**SURVEYORS AFFIDAVIT OF CORRECTION
CARRIAGE MEADOWS NORTH FILING NO. 1
RECEPTION NO. 218714242**

THAT: I AM A LICENSED PROFESSIONAL LAND SURVEYOR IN THE STATE OF COLORADO AND
THAT: I PREPARED THE PLAT OF "CARRIAGE MEADOWS NORTH FILING NO. 1" AS RECORDED UNDER RECEPTION NO. 218714242 IN THE RECORDS OF EL PASO COUNTY, COLORADO.

AFFIANT FURTHER STATES THAT: CERTAIN ERRORS WERE MADE ON THE FIRST SHEET OF SAID PLAT AS FOLLOWS:

FINAL PLAT
CARRIAGE MEADOWS NORTH
FILING NO. 1
JOB NO. 70-055
DATE PREPARED: 12/06/2017
DATE REVISED: 01/29/2018

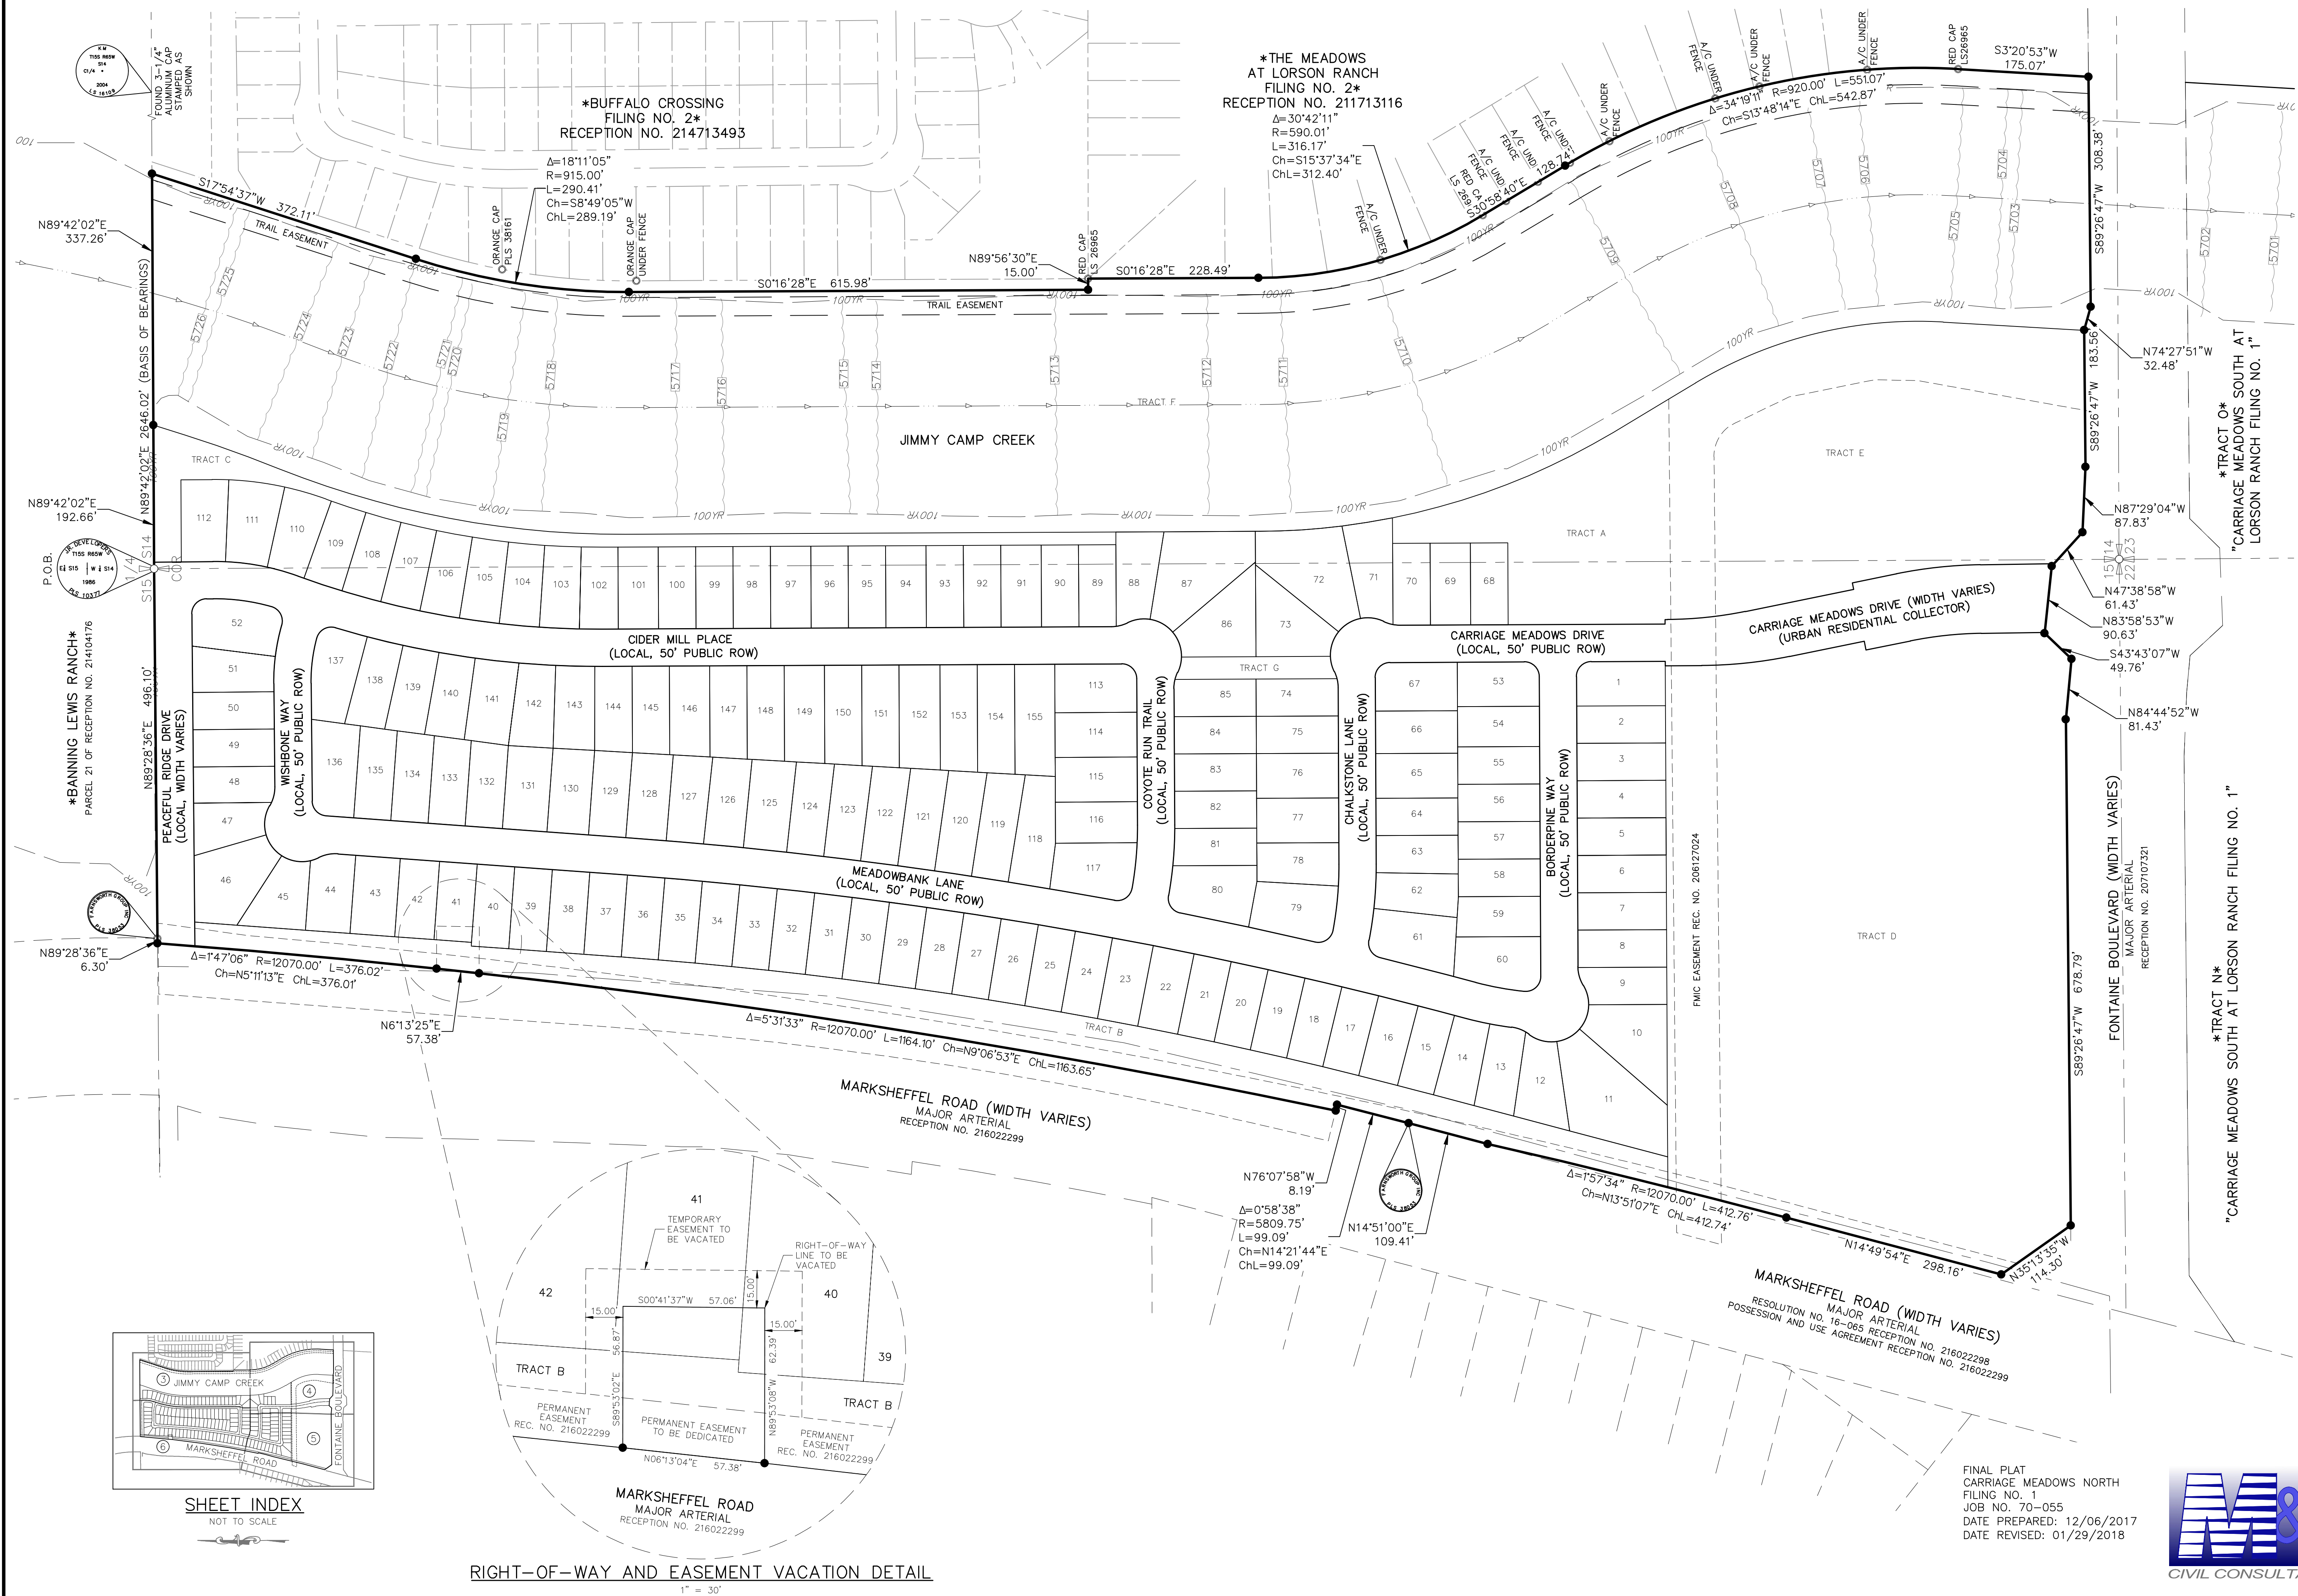
AS STATED ON THE PLAT UNDER "FEES":

<i>Gas</i> DRAINAGE FEE	CREDITS USED THIS FILING	\$ 470,948.00
JIMMY CAMP CREEK SURETY FEE:	CREDITS USED THIS FILING	\$ 210,869.00
BRIDGE FEE:	CREDITS USED THIS FILING	\$ 22,027.00
SCHOOL FEE:	FEES NOT DUE PER THE SCHOOL LAND AGREEMENT AS RECORDED AT RECEPTION NO. 212042170	
PARK FEE:	<i>Area 4</i>	\$ 66,650.00
URBAN PARK FEE:	<i>Area 4</i>	\$ 42,106.00

IS HEREBY AMENDED TO READ;

<i>Gas</i> DRAINAGE FEE:	CREDITS USED THIS FILING	\$ 470,948.00 296,184.00
JIMMY CAMP CREEK SURETY FEE:	CREDITS USED THIS FILING	\$ 210,869.00 132,618.00
BRIDGE FEE:	CREDITS USED THIS FILING	\$ 22,027.00 13,853.00
SCHOOL FEE:	FEES NOT DUE PER THE SCHOOL LAND AGREEMENT AS RECORDED AT RECEPTION NO. 212042170	
PARK FEE:	<i>Area 4</i>	\$ 66,650.00
URBAN PARK FEE:	<i>Area 4</i>	\$ 42,106.00

AFFIANT FURTHER STATES THAT THE AFOREMENTIONED PLAT OF "CARRIAGE MEADOWS NORTH FILING NO. 1" IS HEREBY CORRECTED TO CONFORM TO THE ABOVE DESCRIBED AFIDAVIT AS IF SAID CORRECTION HAD BEEN RE-RECORDED WITH THE PROPER FEE AMOUNTS AS SHOWN HEREON.
